From: Patman, Oscar
Sent: 26 January 2026 09:00
To: _planningadvice
Subject: FW: Consultation - H12-1121-25: VILLA FARM
Attachments: LUTTON TPO NO 1.pdf

H12-1121-25: VILLA FARM

Proposal: Proposed Vehicular Access

Location: VILLA FARM LUTTON GARNSGATE

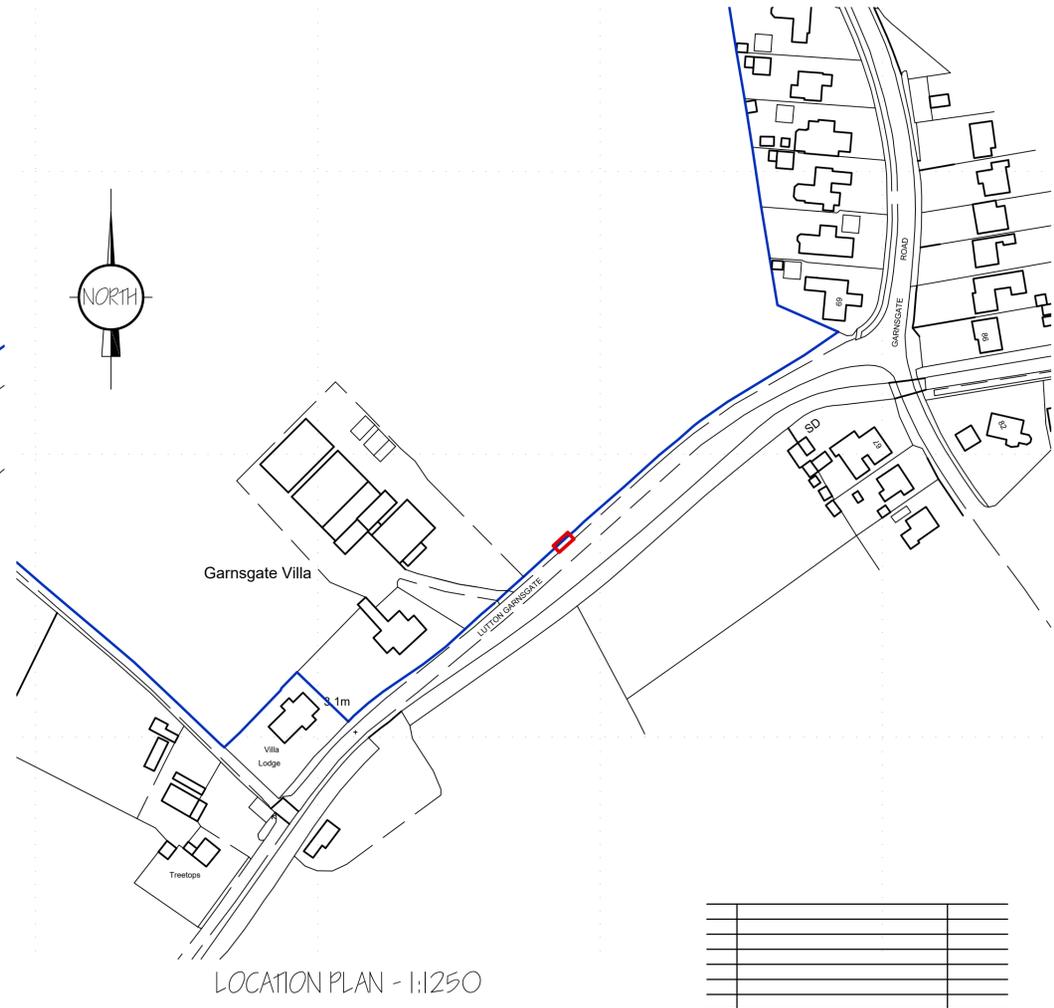
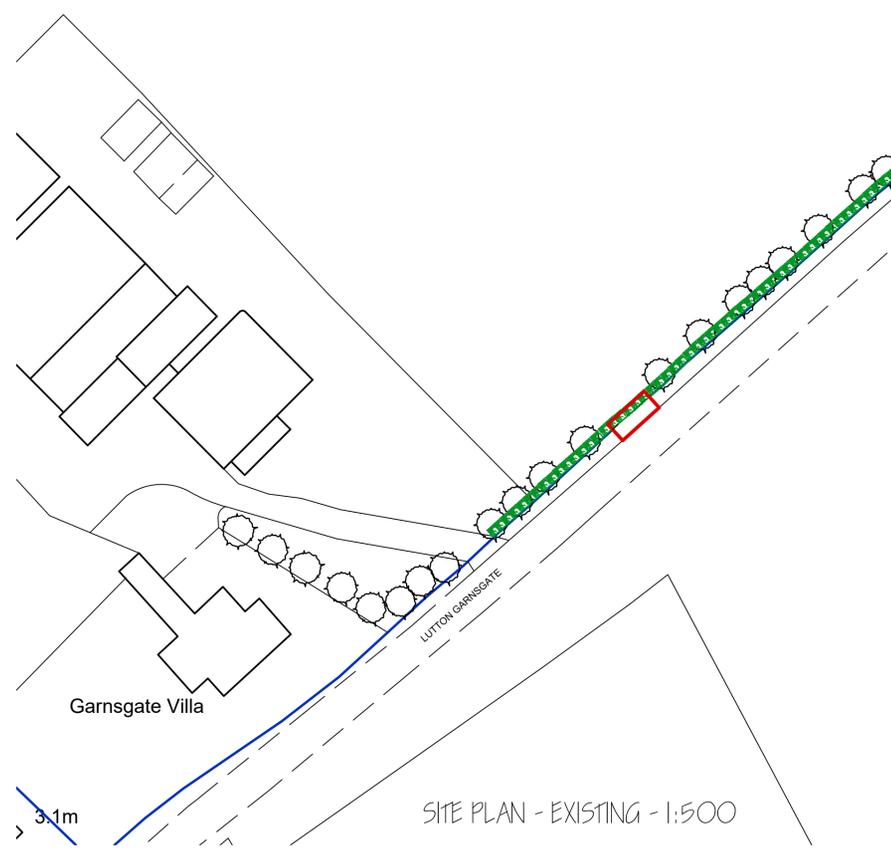
As can be seen from the attached Tree Preservation Order, the proposal would appear to affect the Root Protection Area of at least one preserved tree and probably require some minor crown reduction too.

Firstly, it is strongly recommended that the access is moved to outside the Root Protection Area of any significant or protected trees.

Secondly if determined to pursue this Application as drawn; that the positions, canopy spreads and Root Protection Areas of all trees adjoining the proposed access are clearly shown to scale on a plan.

Root Protection Areas should be calculated using the method recommended in British Standard 5837:2012,
Trees in relation to design, demolition and construction– Recommendations.
